Our Ref: EP/82/19/HH

**Town & Country Planning Act 1990 (as amended)
Town & Country Planning (Development Management Procedure) (England) Order 2015
Application for Planning Permission for Works or Extension to a Dwelling**

Development Change of boundary treatment following complaint from neighbour via council

Location 31 Cheviot Close East Preston

SITE PLAN 1:500

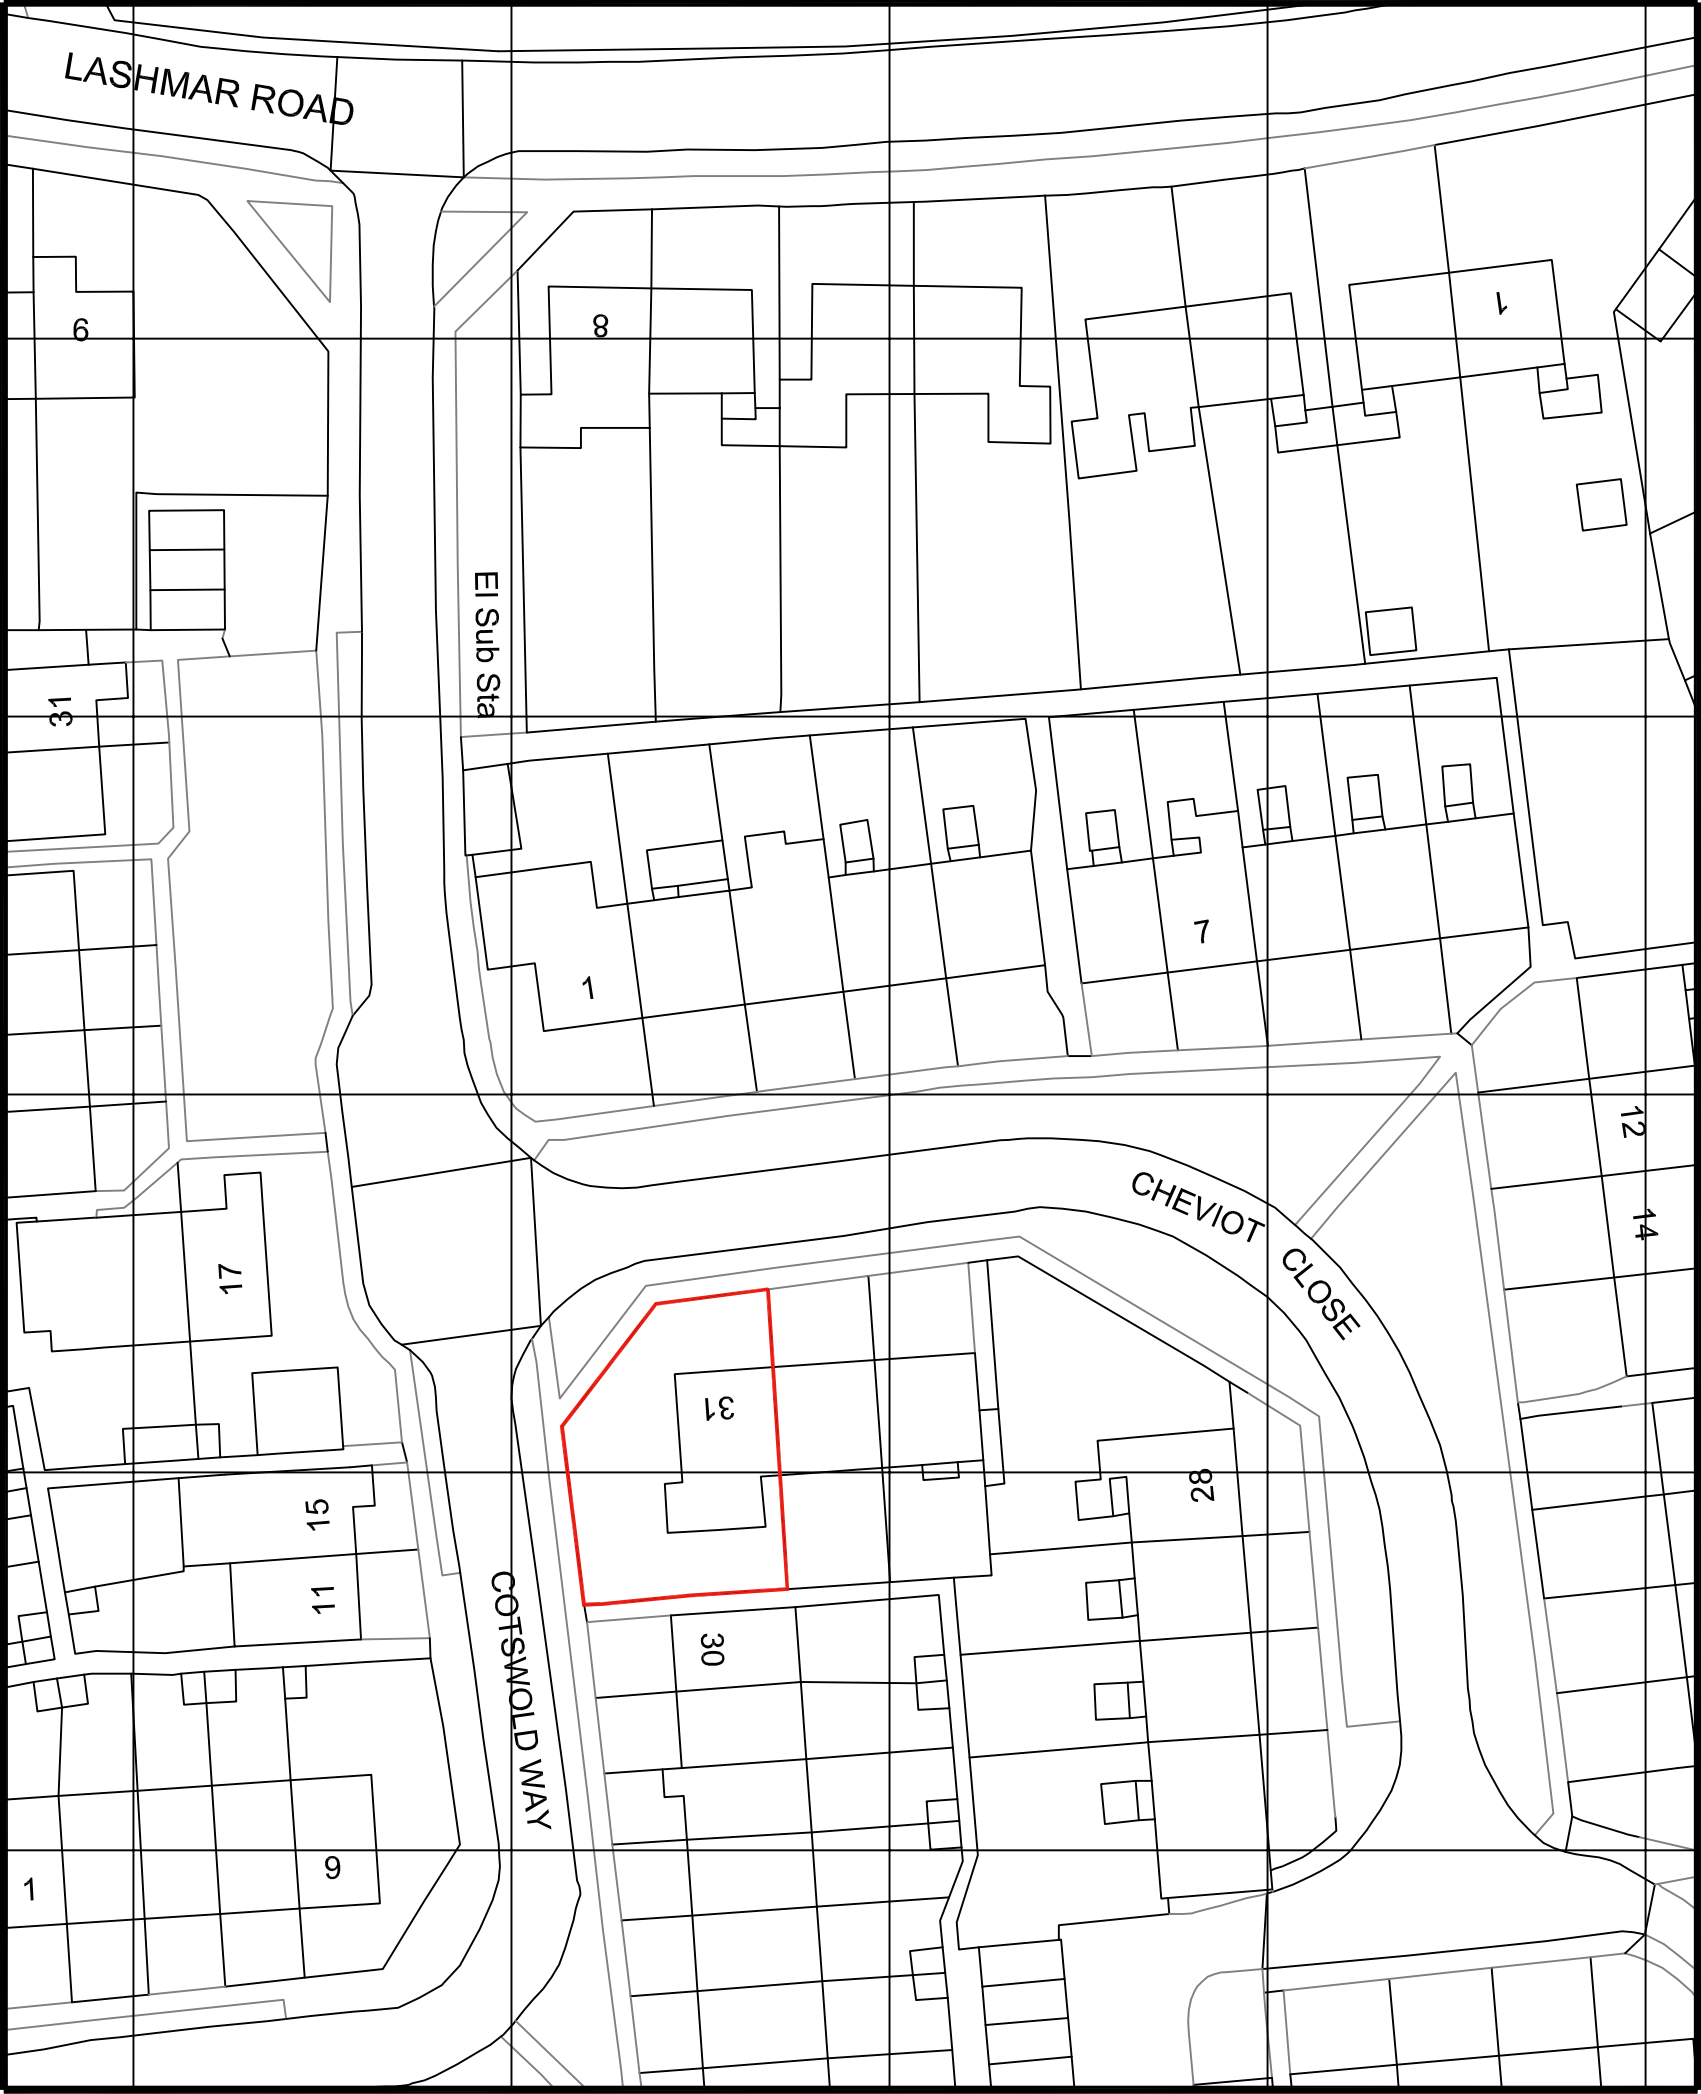
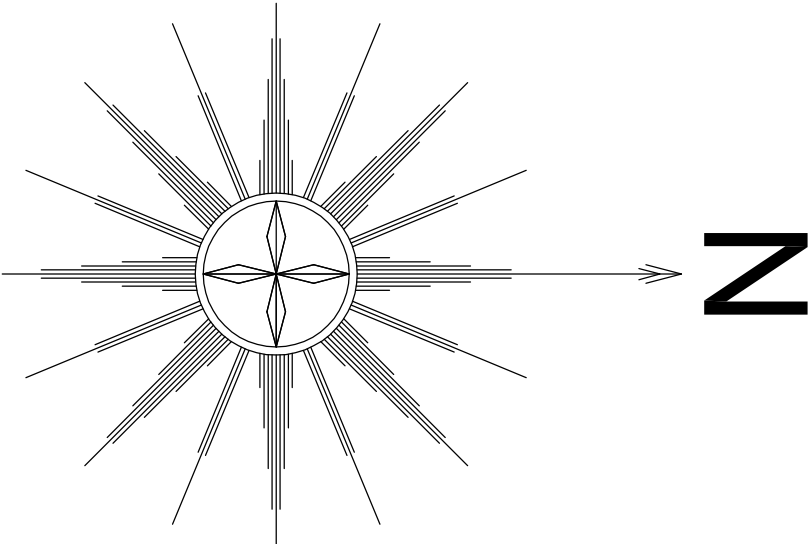
Plans: The plans of the proposed fence needs to be scale or alternatively please provide a scaled elevation of the fence.
